# **A1 in Northumberland: Morpeth to Ellingham**

**Scheme Number: TR010059**

## **Appendix A Response to RR-04 Environment Agency**

<b>Regulation Reference:</b>	APFP Regulation Rule 8(1)(c)
<b>Planning Inspectorate Scheme Reference</b>	TR010059
<b>Application Document Reference</b>	TR010059/7.9.1
<b>Author:</b>	A1 in Northumberland: Morpeth to Ellingham Project Team, Highways England

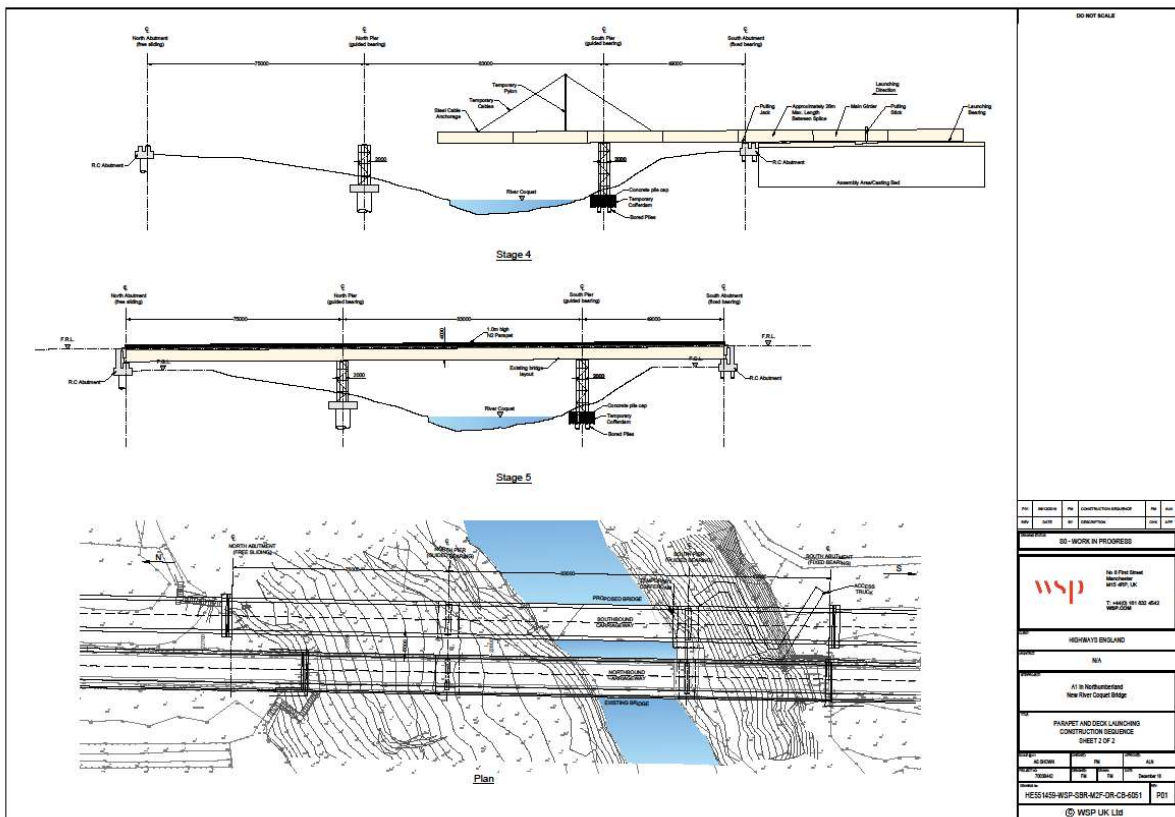
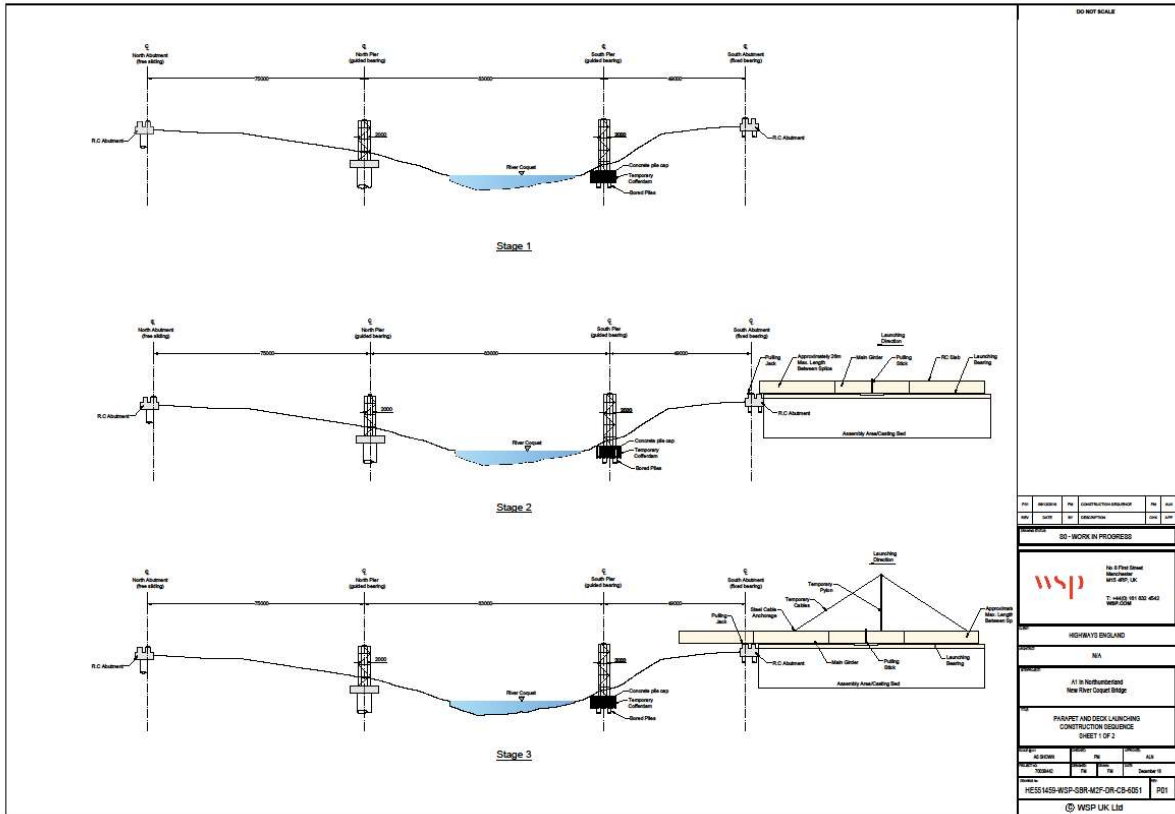
<p>A.67 Appendix 10.7 Geomorphology Assessment: Solution</p>	<p>6. The footprint of the sheet piling and the foundations of the pier will be greater than the pier itself. The impact will be greatest during construction, has this been taken into account;</p>	<p>The potential construction impacts of the pier and its foundations were included in the assessment, including consideration of the construction methods and footprint of the sheet piling and foundations. Assessment of both construction and operational impacts were assessed (refer to Appendix 10.7 Part A Geomorphology Assessment [APP-260] of the ES).</p> <p>The Applicant's Geomorphologist is now doing 2D hydraulic modelling to assess potential impacts of construction and operation of the Proposed Scheme on the geomorphological processes compared with baseline. The footprint of the sheet piling and foundations of the pier has been included within the modelling for the construction phase for a range of flood events, as agreed with the Environment Agency Geomorphologist on 10 December 2020 and included within the circulated Meeting Minutes. A report presenting the results of the 2D modelling will be submitted at Deadline 3.</p>
